Your Ref: EN010079  
Date: 7 June 2019

My Ref: 8/1/18/0088  
Tel No.: 01603 223231  
Email: john.r.shaw@norfolk.gov.uk

**Application by:- Norfolk Vanguard Limited for an Order Granting Development Consent for the Norfolk Vanguard Offshore Wind Farm Project.**

**Requested trenchless crossing of the B1149**

TITLE  
B1149 TRAFFIC MANAGEMENT

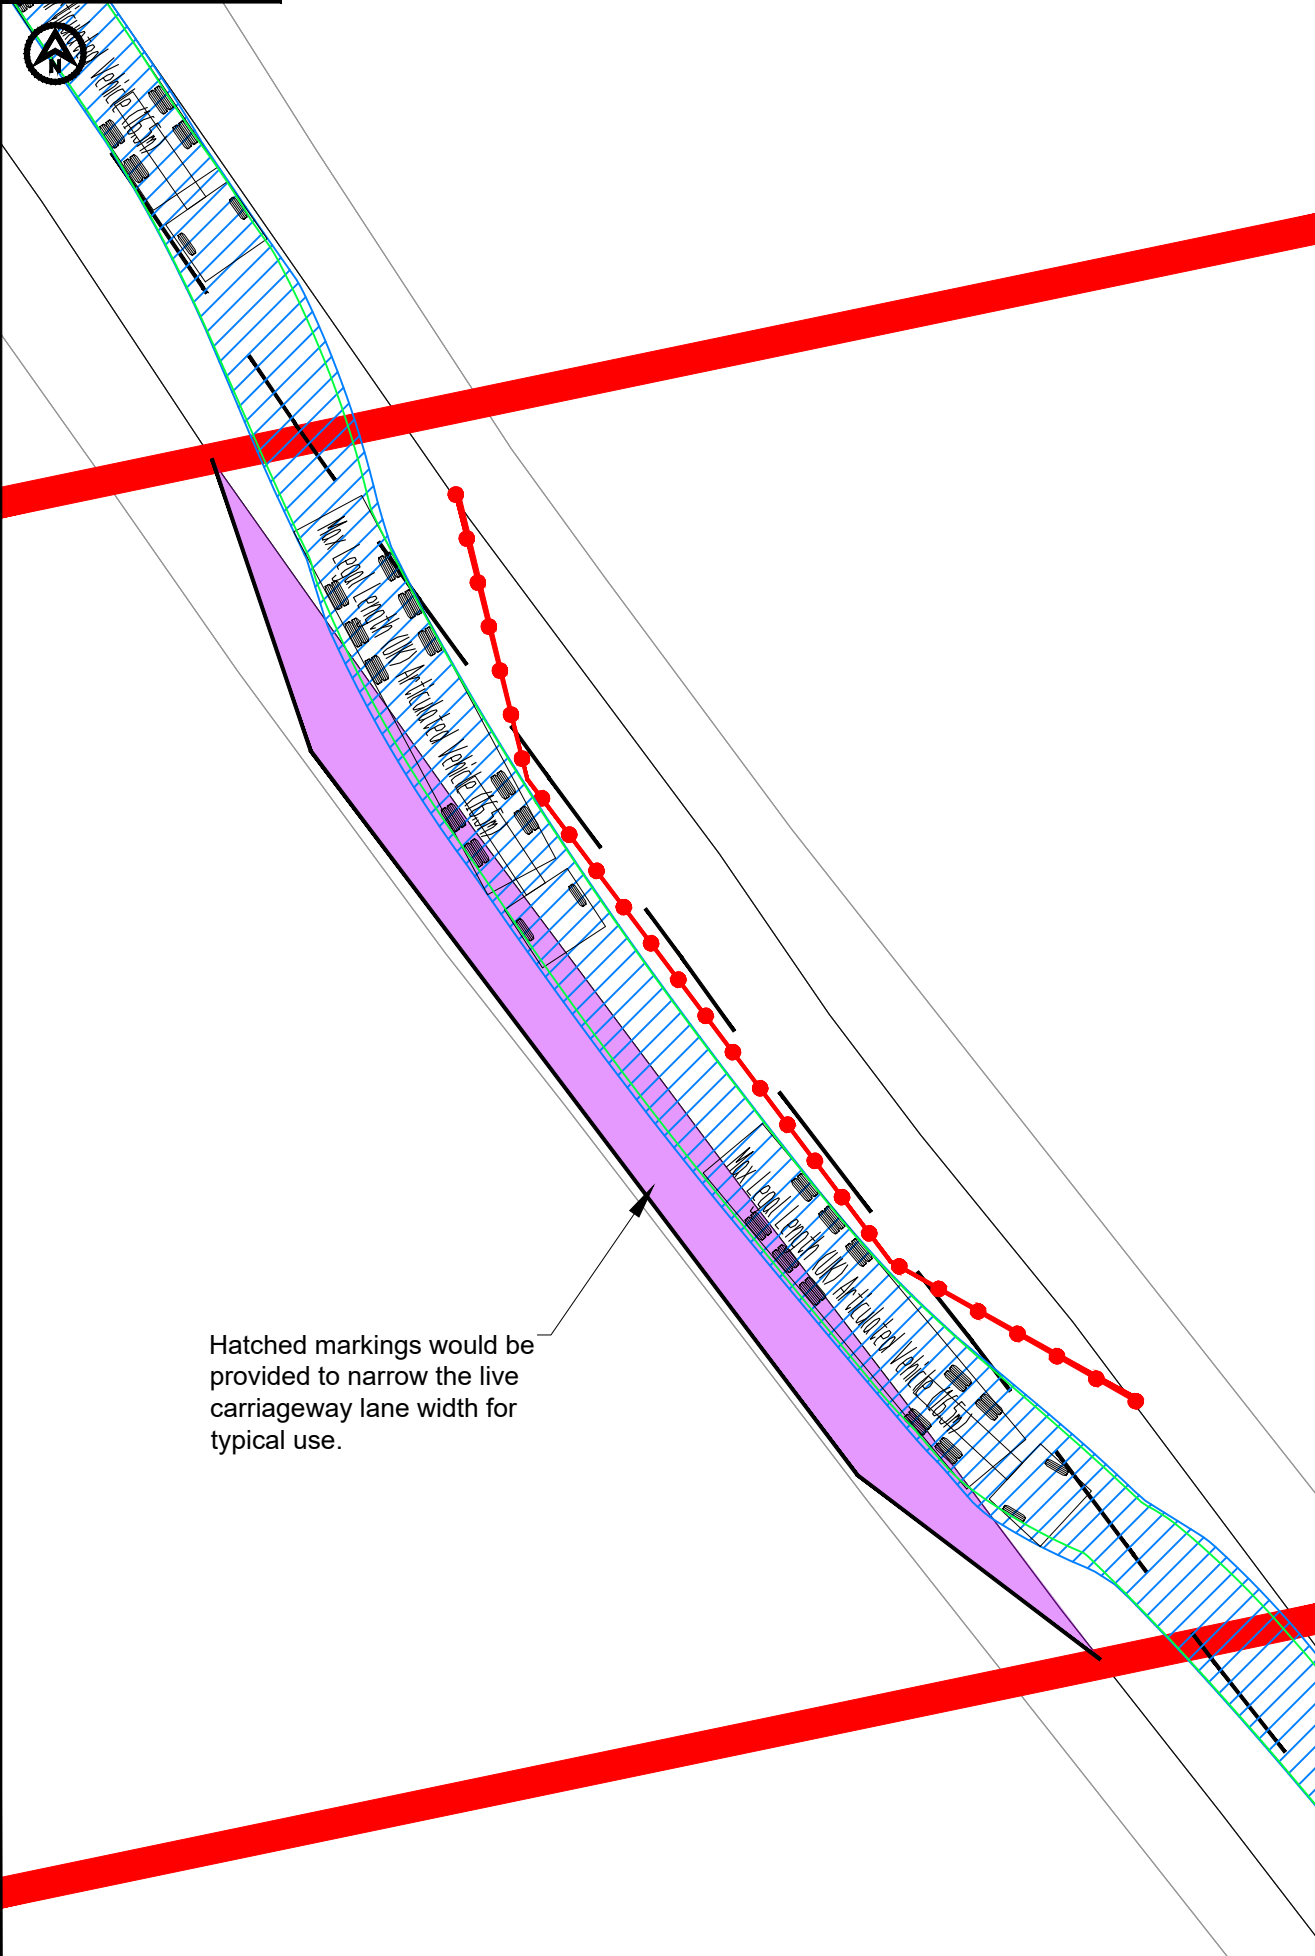
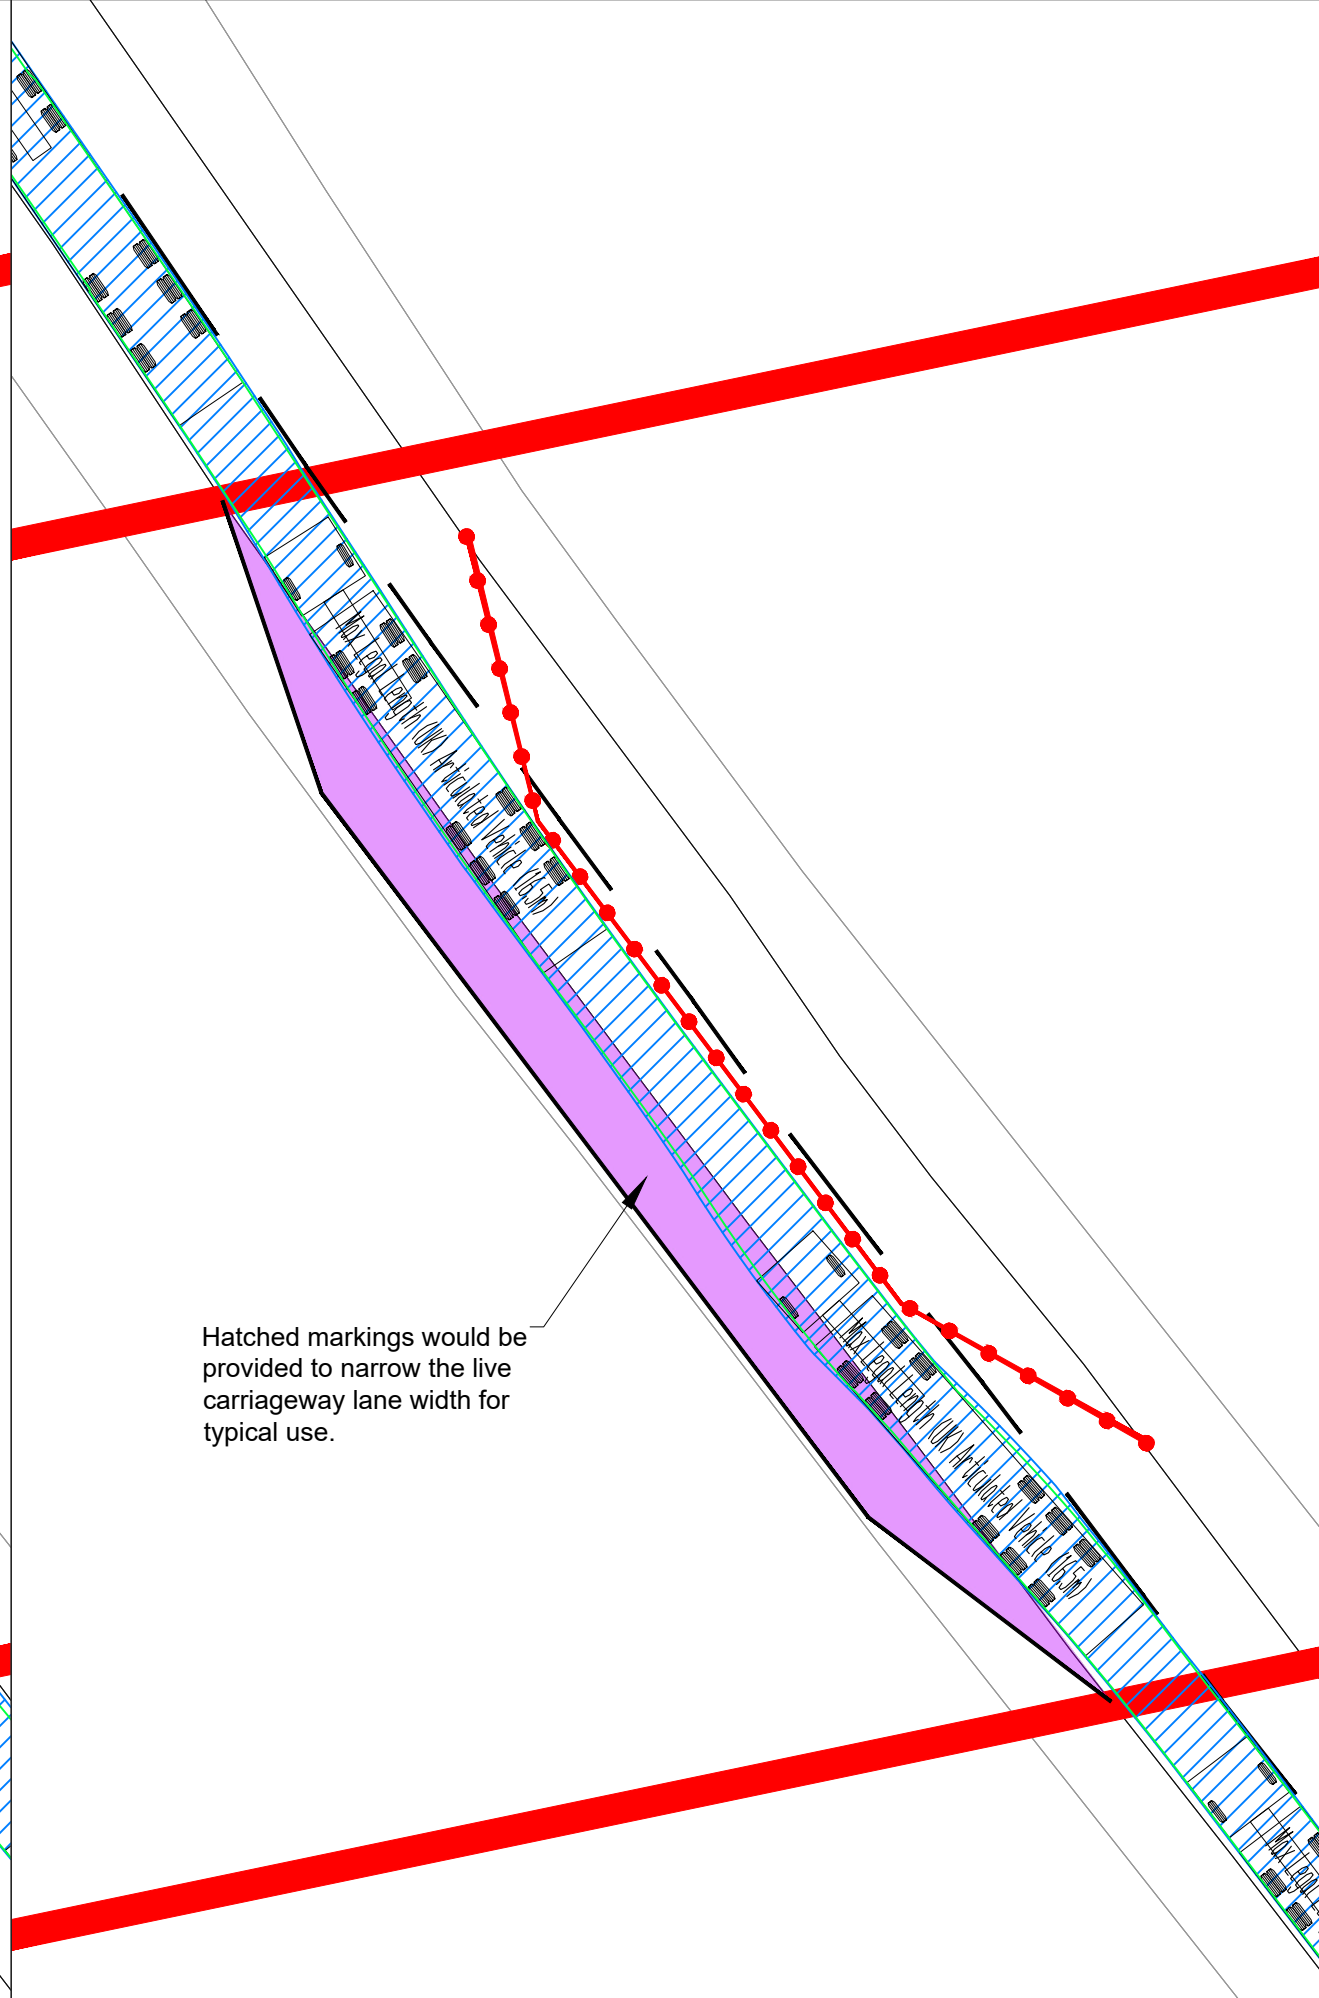
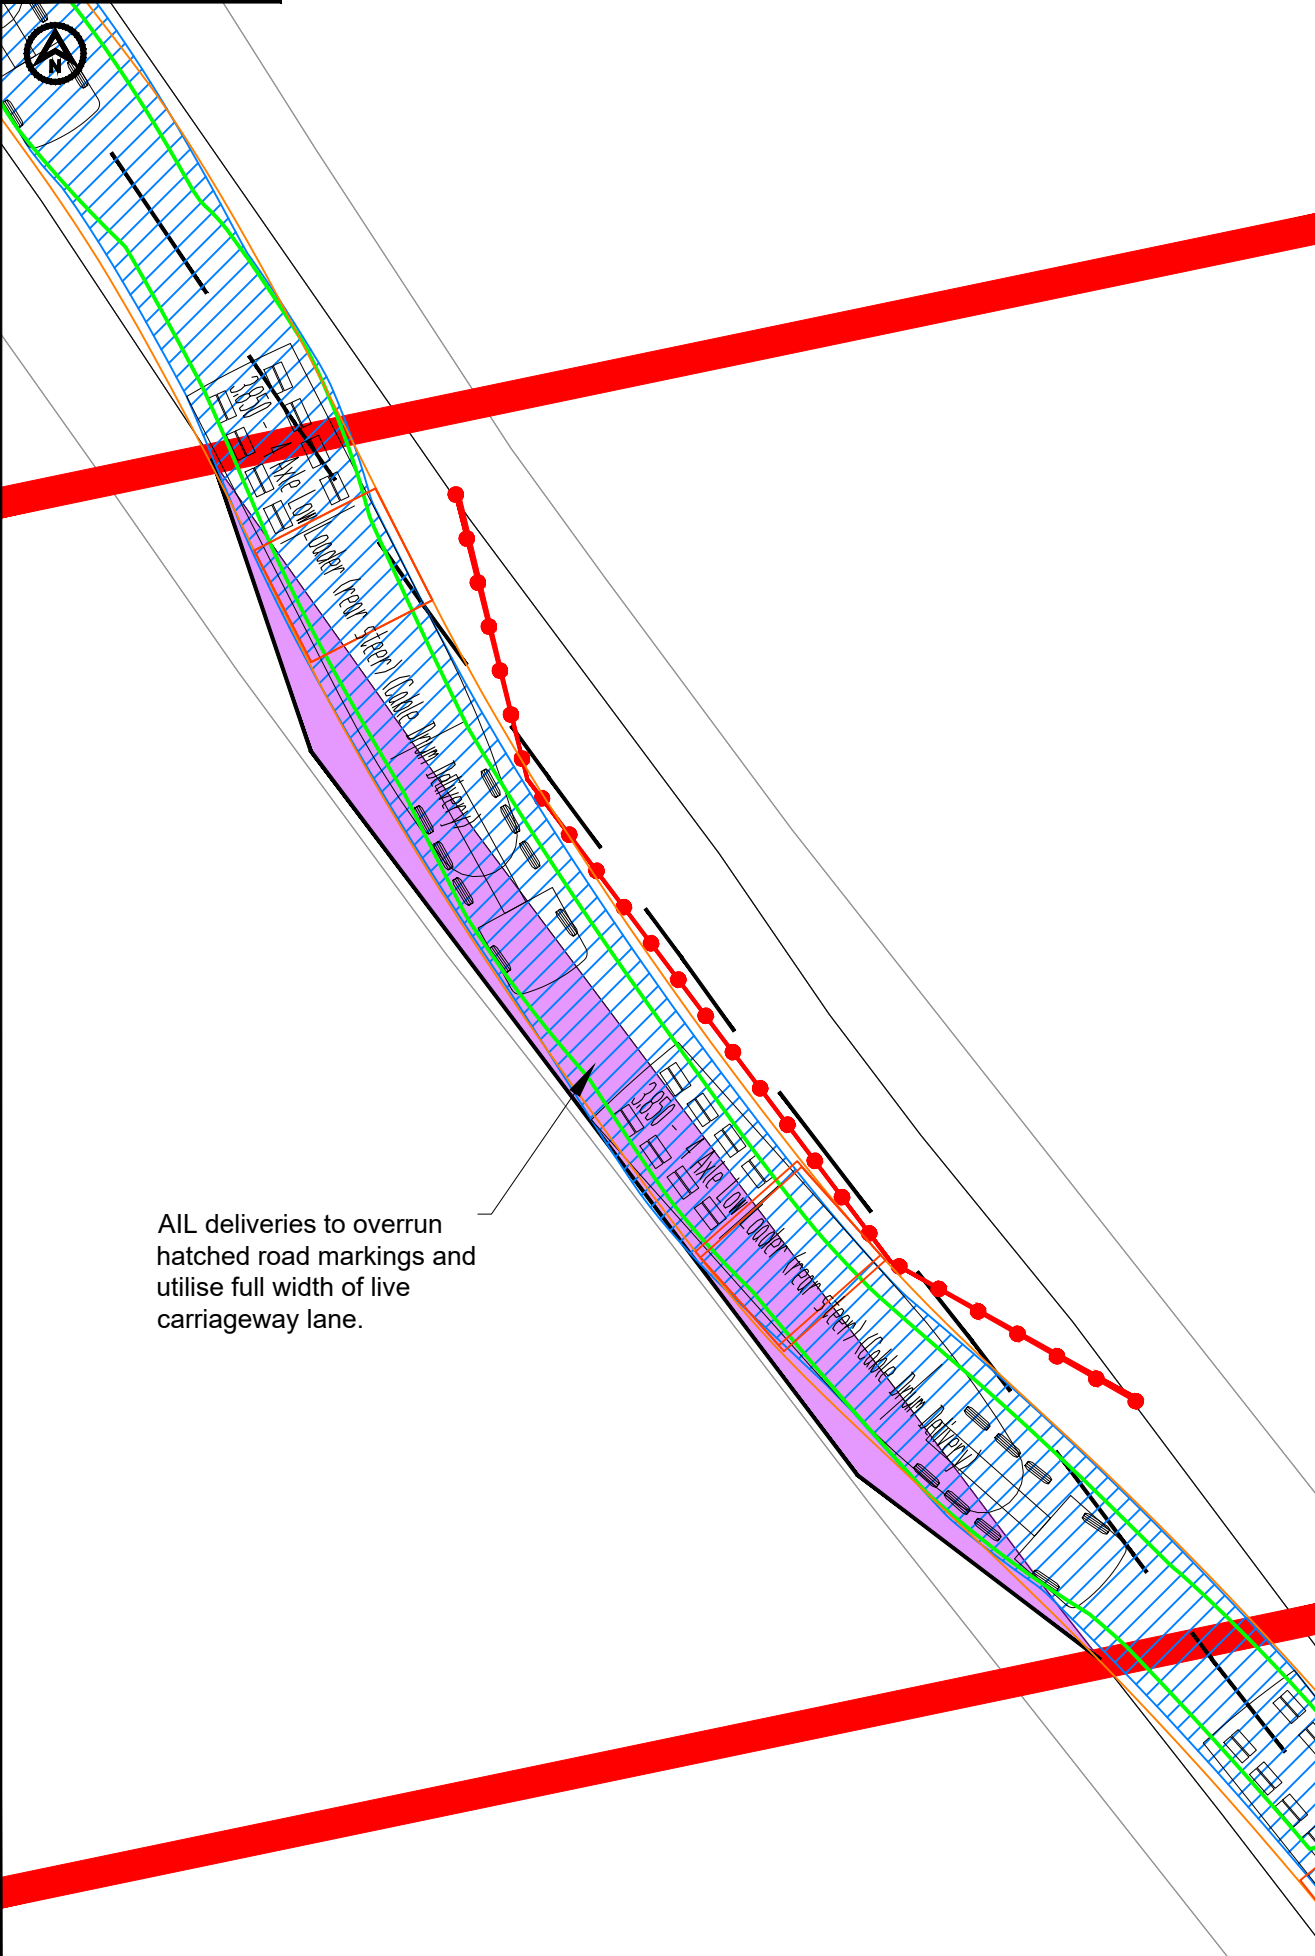
The applicants finally submitted a trenchless crossing report to the County Council on 15 May, which included details of the applicants proposed traffic management measures. The drawings attached to the report lacked detail and accordingly we subsequently asked the applicants to submit swept path drawings to demonstrate that Hornsea 3's vehicles would be able to negotiate the roadworks in safety.

Swept path drawings were submitted to us on 3 June and we responded on the 5<sup>th</sup> June to say the safety zone for the works was shown incorrectly and accordingly our concerns had not been addressed. **Contrary to the applicants claim within the position statement issued to you yesterday – the swept path drawings DO NOT in any way**

**demonstrate that the traffic management can be designed so that abnormal loads can physically negotiate the roadworks.**

- The safe working distance of 1.2m can be accommodated in the final design.  
In response, this is clearly not acceptable. There must be a realistic expectation that a safe method of working is achievable. That expectation has not been met.

- The proposed road widening (the pink land) can be widened further to the west within the order limits.  
In response – we fully accept that but widening to the west is not the problem we have identified. The problem lies to the north and south of the pink land and not to the west.

- The coned off area can be narrowed from 20m down to 15m.  
In response – we have not seen any details to show how that would work.
- Speed restrictions could be imposed  
In response – We have already advised the applicants (5<sup>th</sup> June) that whilst this can be reduced with the use of a temporary 30mph speed restriction, it is not so in the case of an excavation exceeding 1.2 metre in depth.

- The deep excavation can be designed to provide additional lateral support and thus ensuring a 0.5m distance of separation would be safe.  
In response – Construction work and road works carried out on public roads has to comply with Chapter 8 of the Traffic Signs Manual, which is aimed at reducing risk of harm to workers and the public. To comply with Chapter 8, deep excavations need a safe working area of 1.2m and not 0.5m as proposed.

- Norfolk County Council indicate within their position statement at 30.5.19 that land within the highway boundary, outside the Order limits, **would be available** to extend the tapers of the road widening if required, depending on the final design.  
In response – this is simply not true. The position statement says – “if additional land is required outside the pink land, then the applicant needs to demonstrate that they either have control of that land or that it forms part of the public highway.” To date they have not done either of these.

In the circumstances, the County Council remains of the view that trenchless crossing needs to be employed for the B1149 and that the requirement in the DCO needs to be amended accordingly.
